DRB Comments

PROJECT # 1007610

APPLICATION # 08-70523

RE: Lots 11 - 13, Major Acres

**LOTS 12-A AND 13-A
MAJOR ACRES**
(BEING A REPLAT OF A PORTION OF LOT 11 AND
ALL OF LOTS 12 AND 13, MAJOR ACRES)

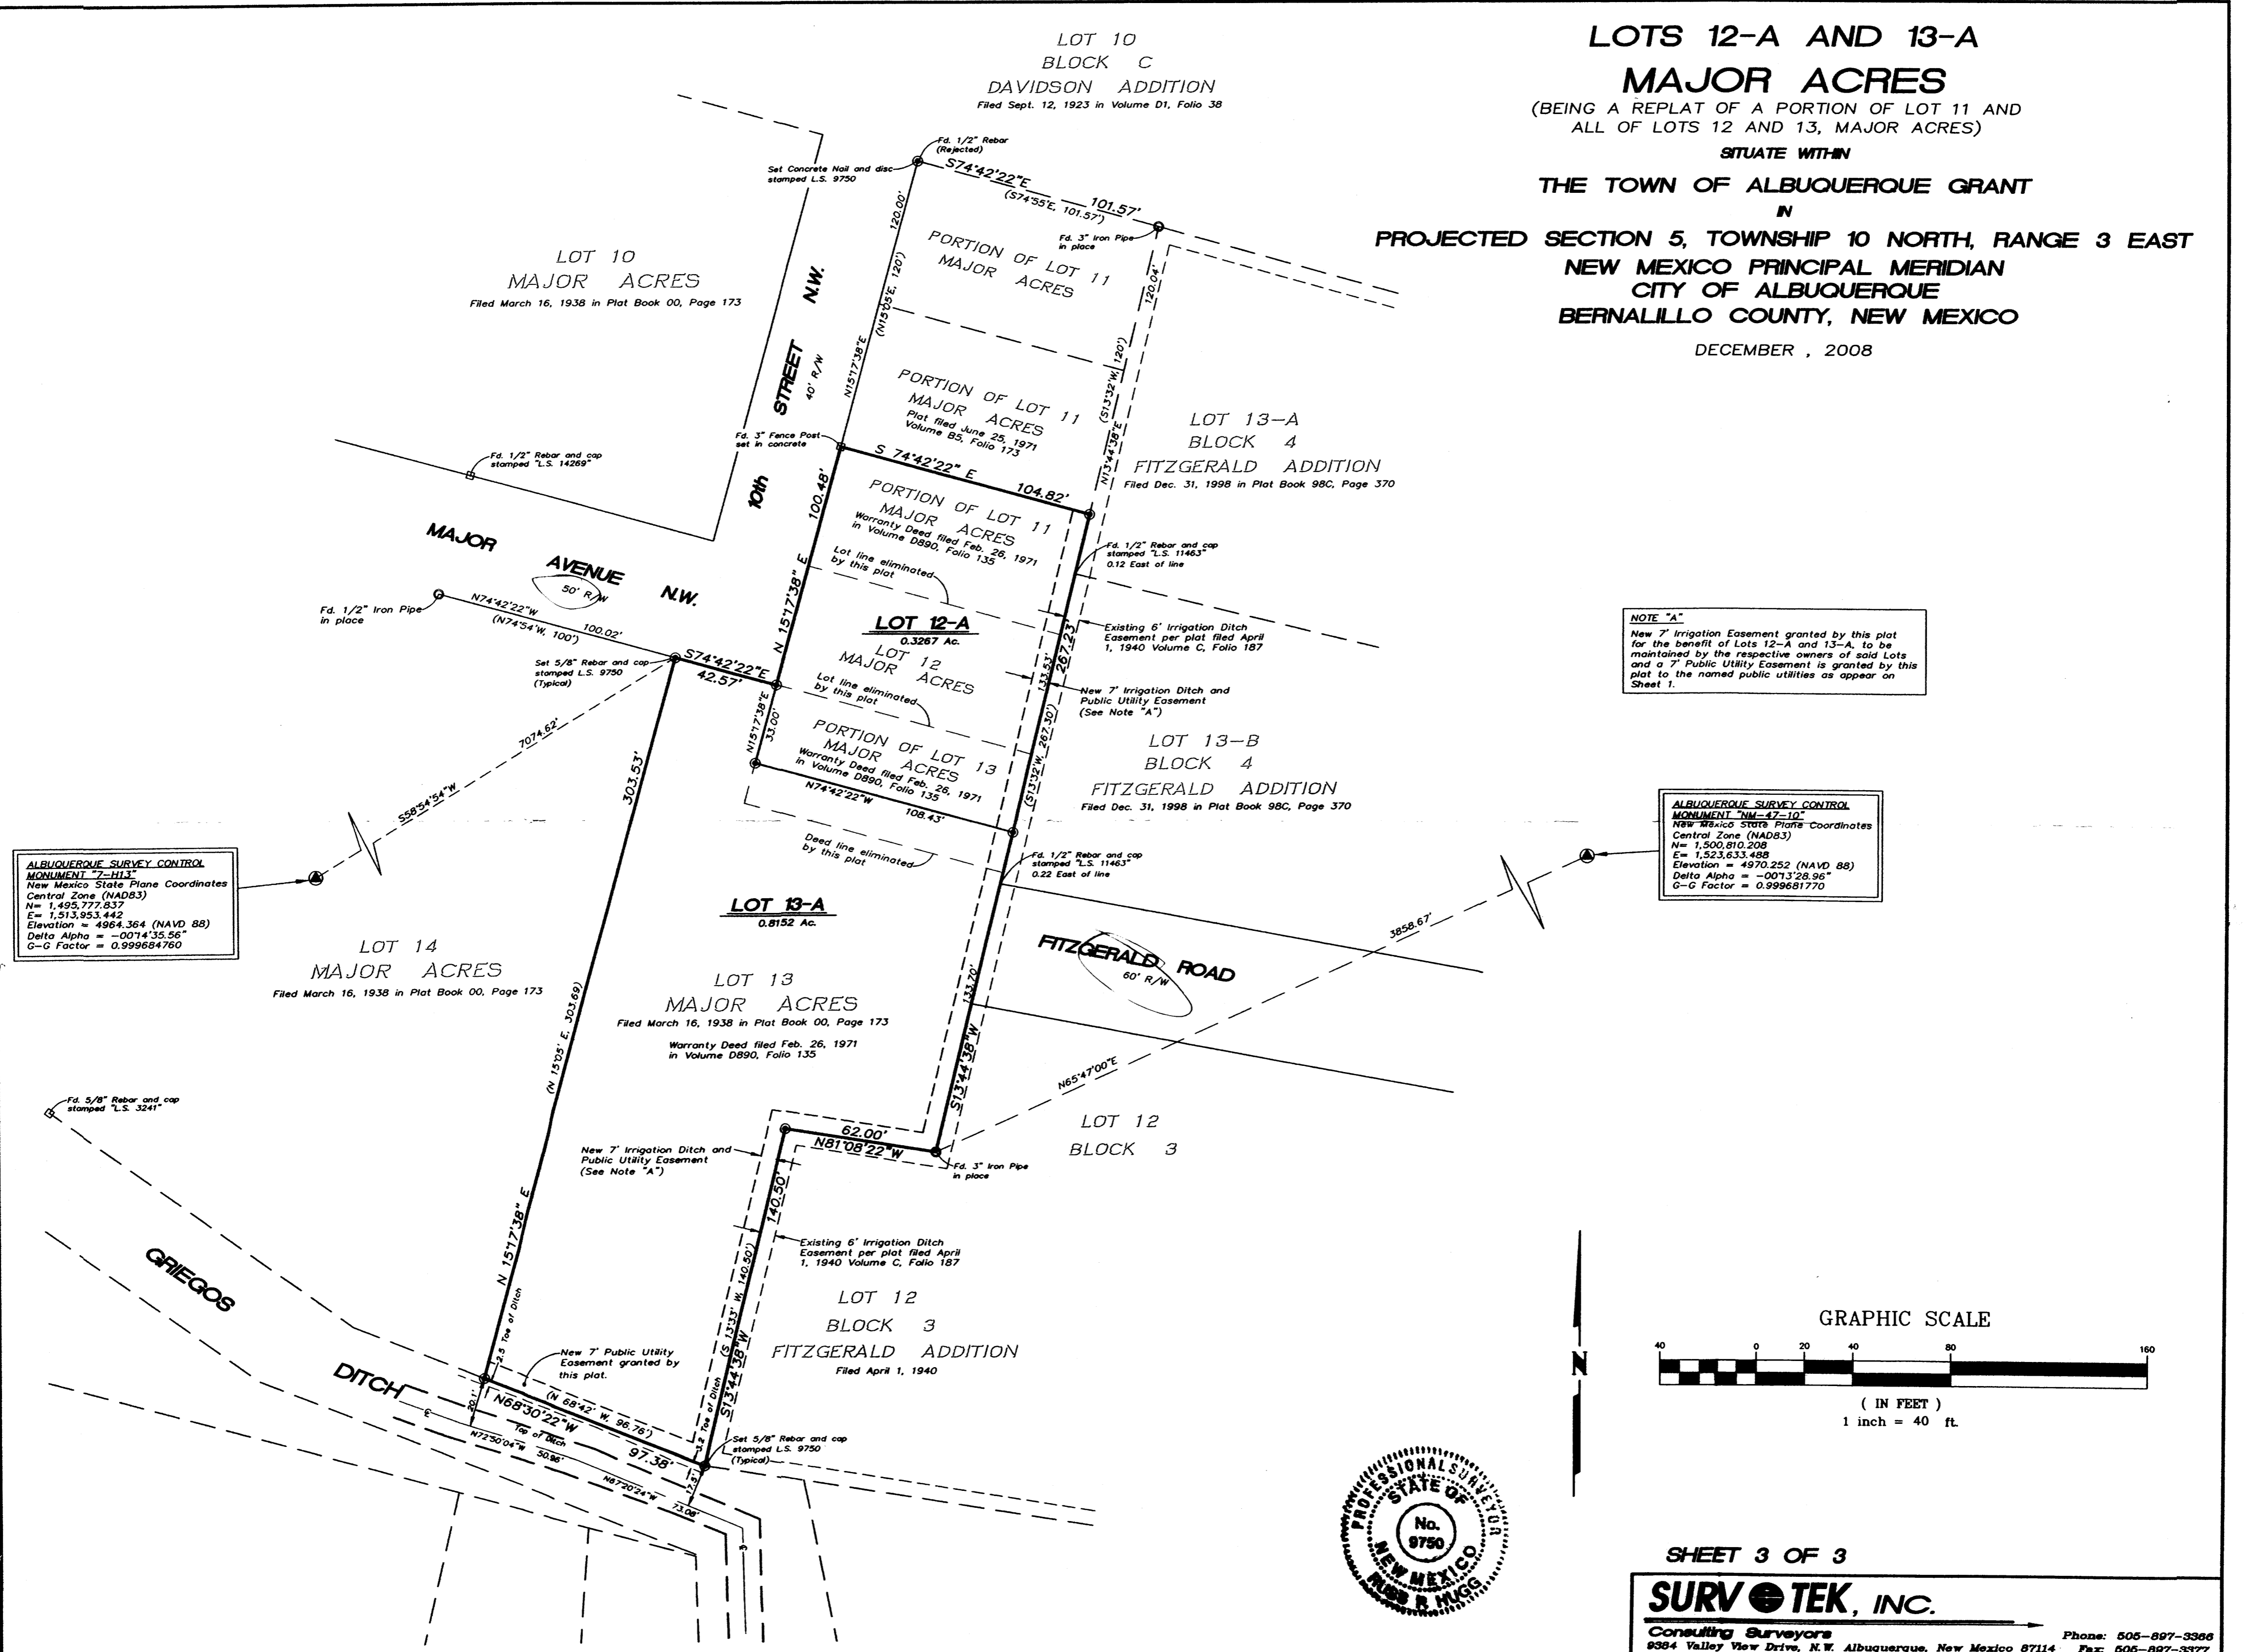
FYI, the Right of Way for Fitzgerald Road scales at 50 feet (not 60)
on both plat and AGIS. *COPY OF ORIGINAL PLAT
ATTACHED*
